**Beaches Yard,  
Horton Road,  
West Drayton**

**Prepared for  
Harvest Land Management**

**Development:** Redevelopment of the site to provide a flexible warehouse facility (Use Class B2/B8) and ancillary office space, with associated HGV loading and servicing bay, car and cycle parking, access arrangements, landscaping and infrastructure.

**Reference:** 75221/APP/2022/2968

Project	Beaches Yard	Project description	Warehouse	Scale	1:50@A1	Job No
Title	Proposed Site Layout Plan	Description	Planning	1:50@A3	0203	Rev
		By	NW	Drawing No	003	—

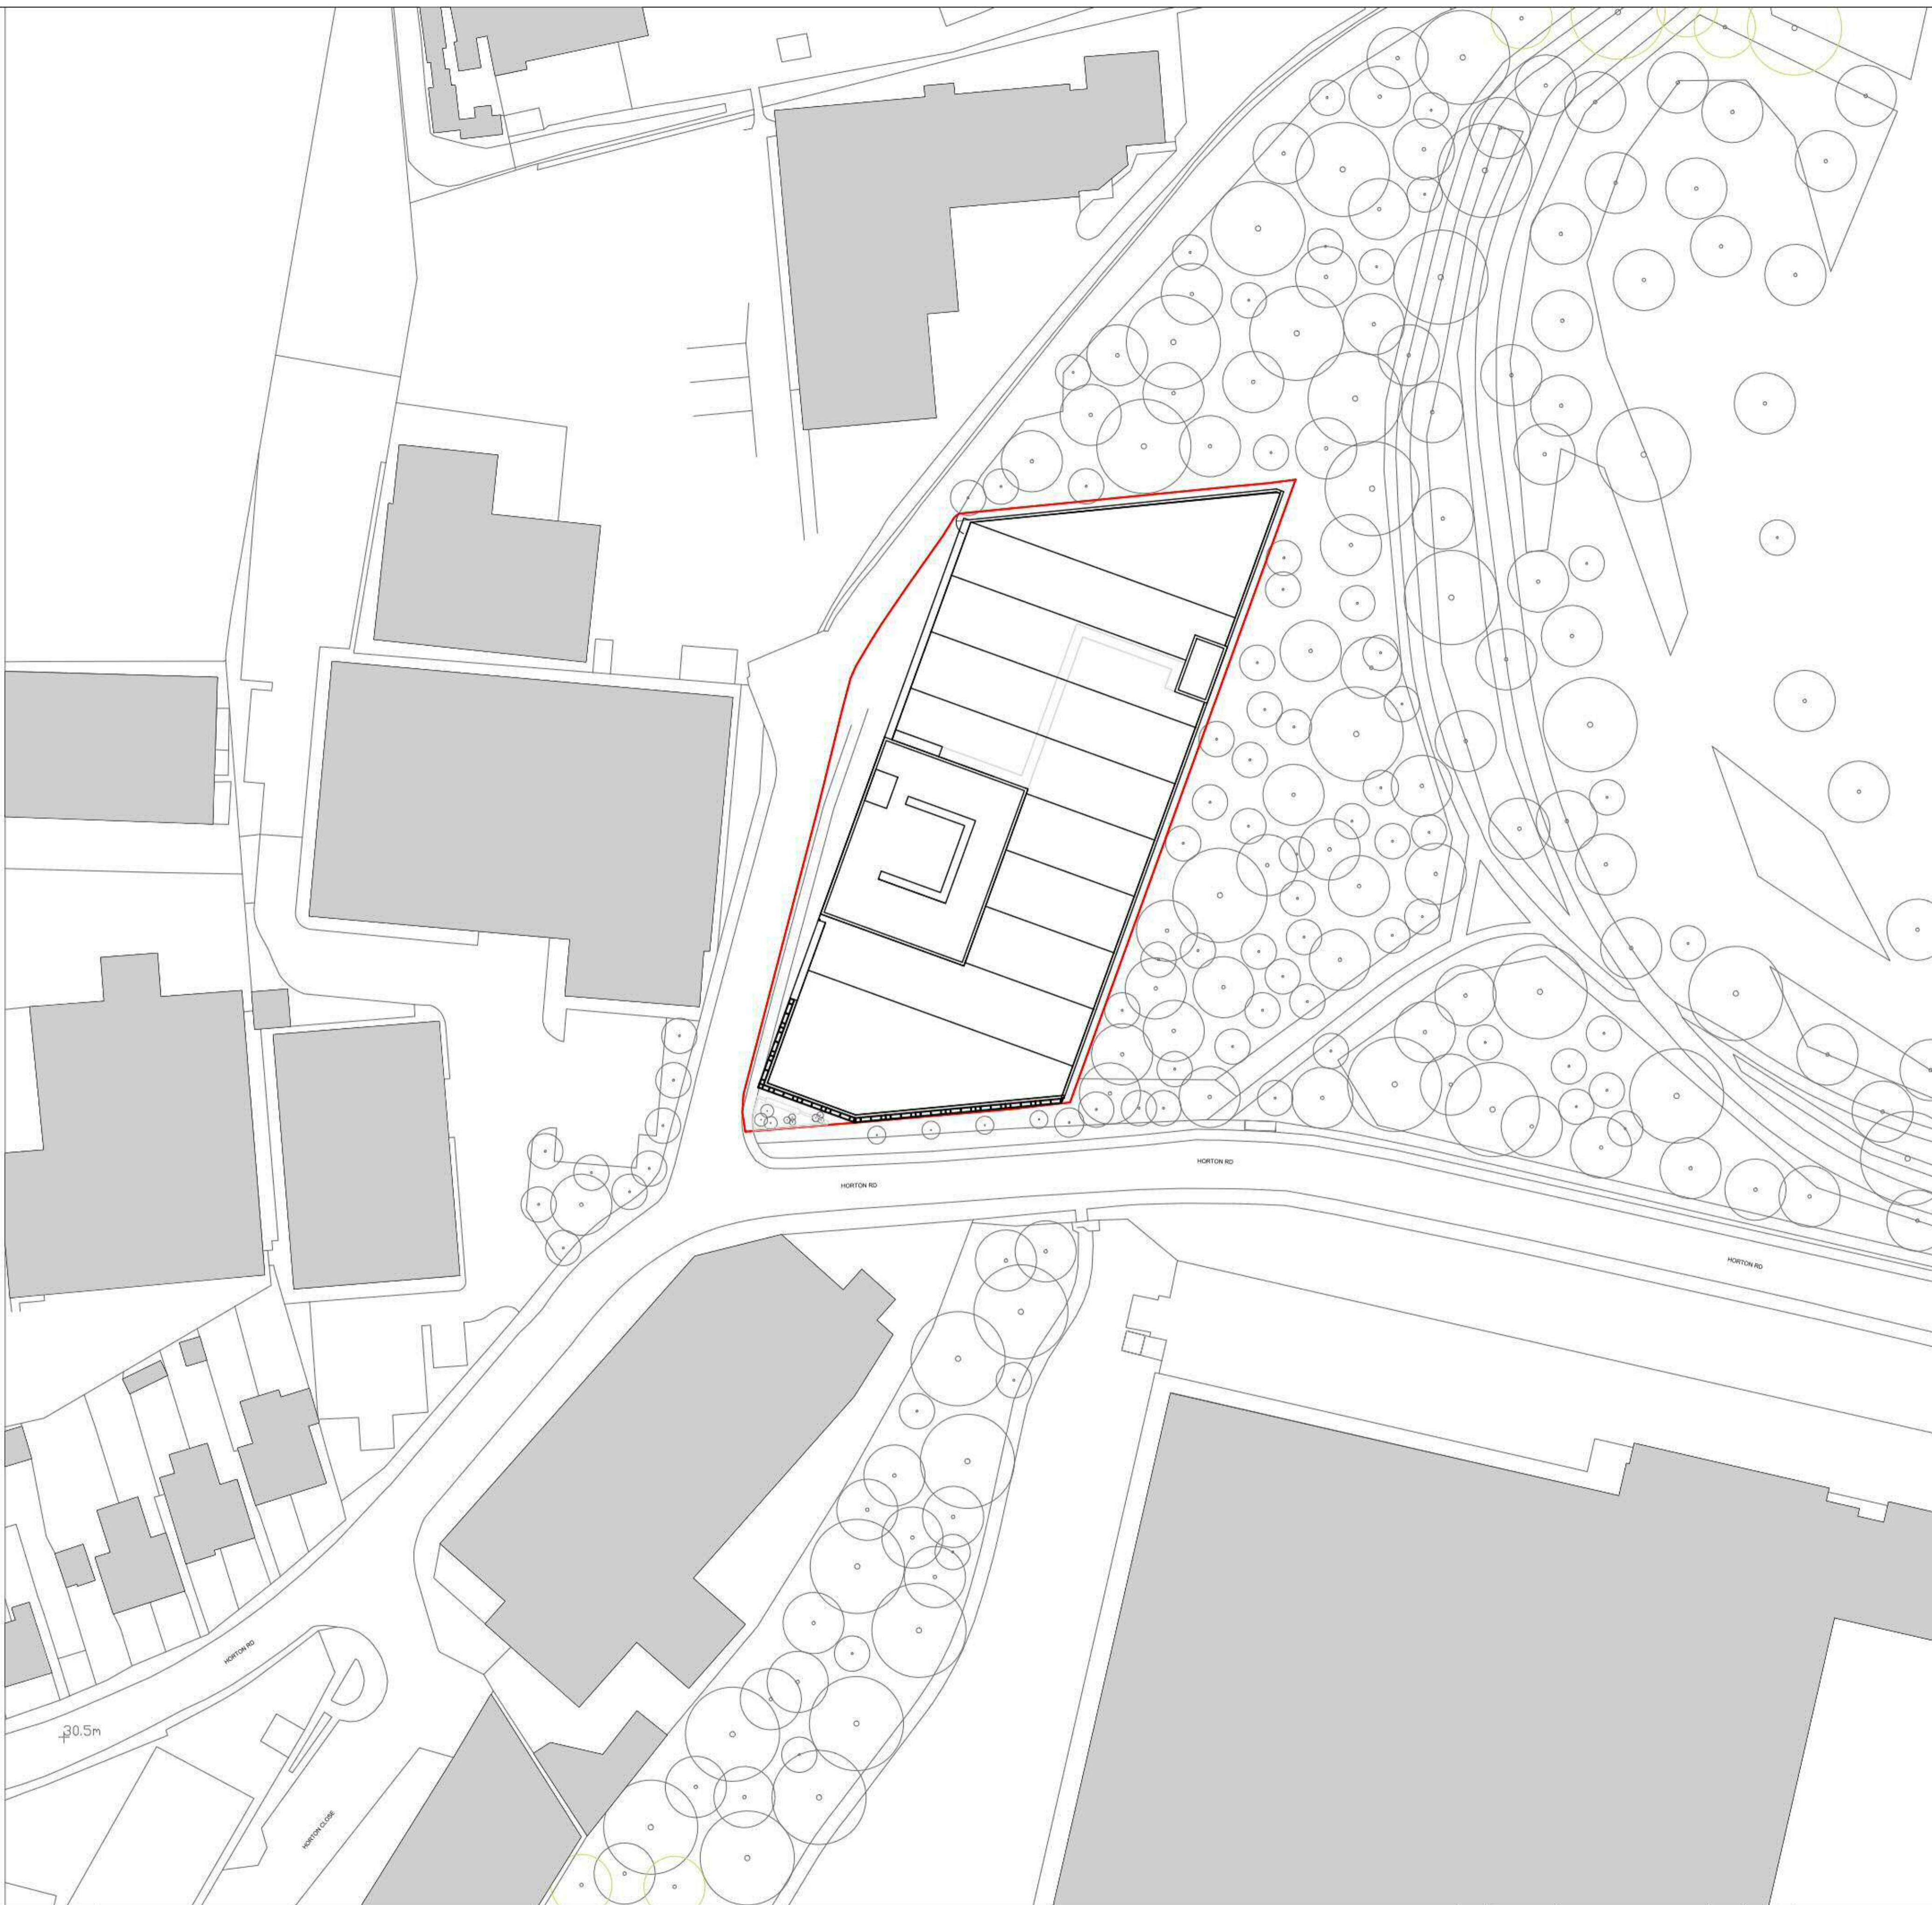
Two separate sets of Highway comments have been provided previously stating that due to the developments locations the Local Plan would be used over the London Plan, this is because it will allow for a higher threshold of on-site parking for staff. According to the published London Borough of Hillingdon Local Plan Part 2 Development Management Policies 2020 parking standards states that development proposals must comply with the relevant parking standards. Therefore, for a development of this type to be within policy 2 spaces plus 1 per 500 sqm of gross floor space which would be 71no. spaces would be required. It is found that the revision of parking provision to 53no. would be in accordance with policy. However, as mentioned already the plans show 53no. whereas the Parking servicing and Management plan firmly states 45no. being provided. The Highway Authority would require the developer to send amended plans showing 45no. on-site parking spaces, instead of 53no. shown on the plans.

Amended plans now indicate that the private road outside of the development are within the applicant control through the new red boundary line that is seen on plans. It is good to see that some enforcement will be made by preventing cars from parking on the road through the installation of double yellows. Nevertheless, the Highway Authority would require that more improvements be made to the road that would improve road safety and make it more suitable for HGV use. It is noted that the footpath will be widened on the side of the development, though this does not lead anywhere for pedestrians to go. Furthermore, nothing has been proposed to restrict vehicles from exiting both the basement car park and loading bay that ensures that drivers check to approaching vehicles. Finally, the Highway Authority would require that the applicant demonstrate how further improvements can be made to the road which increase road safety. This contradicts the published London Plan 2021 Policy T4 Assessing and mitigating transport impacts which states that '*development proposals should not increase road danger*'.

The Highway Authority would require that all pedestrian access into the basement car park be moved onto Horton Road or internally. This would negate the need for a footpath when the road is already narrow and would mean that pedestrians do not interact with entering/exiting vehicles.

As mentioned above the loading bay will include a vehicle turntable which will rotate the HGVs within the site. There is still the high risk that this can malfunction which will lead to vehicles being unable to turnaround within the development. HGVs should be able to turn on plot without the necessity of machinery, as HGVs are the fundamental use of the site. The Highway Authority will be unable to support any application that sees the implementation of a vehicle turntable. Swept path drawings have been again submitted, though they still indicate that HGVs turning left from Horton Road onto the private road would be very close to the footpath and over sweeping it. This contradicts the published London Plan 2021 Policy T7 Deliveries, servicing and construction which states that development proposal for new consolidation and distribution facilities should '*reduce road danger, noise and emission from freight trips*'.
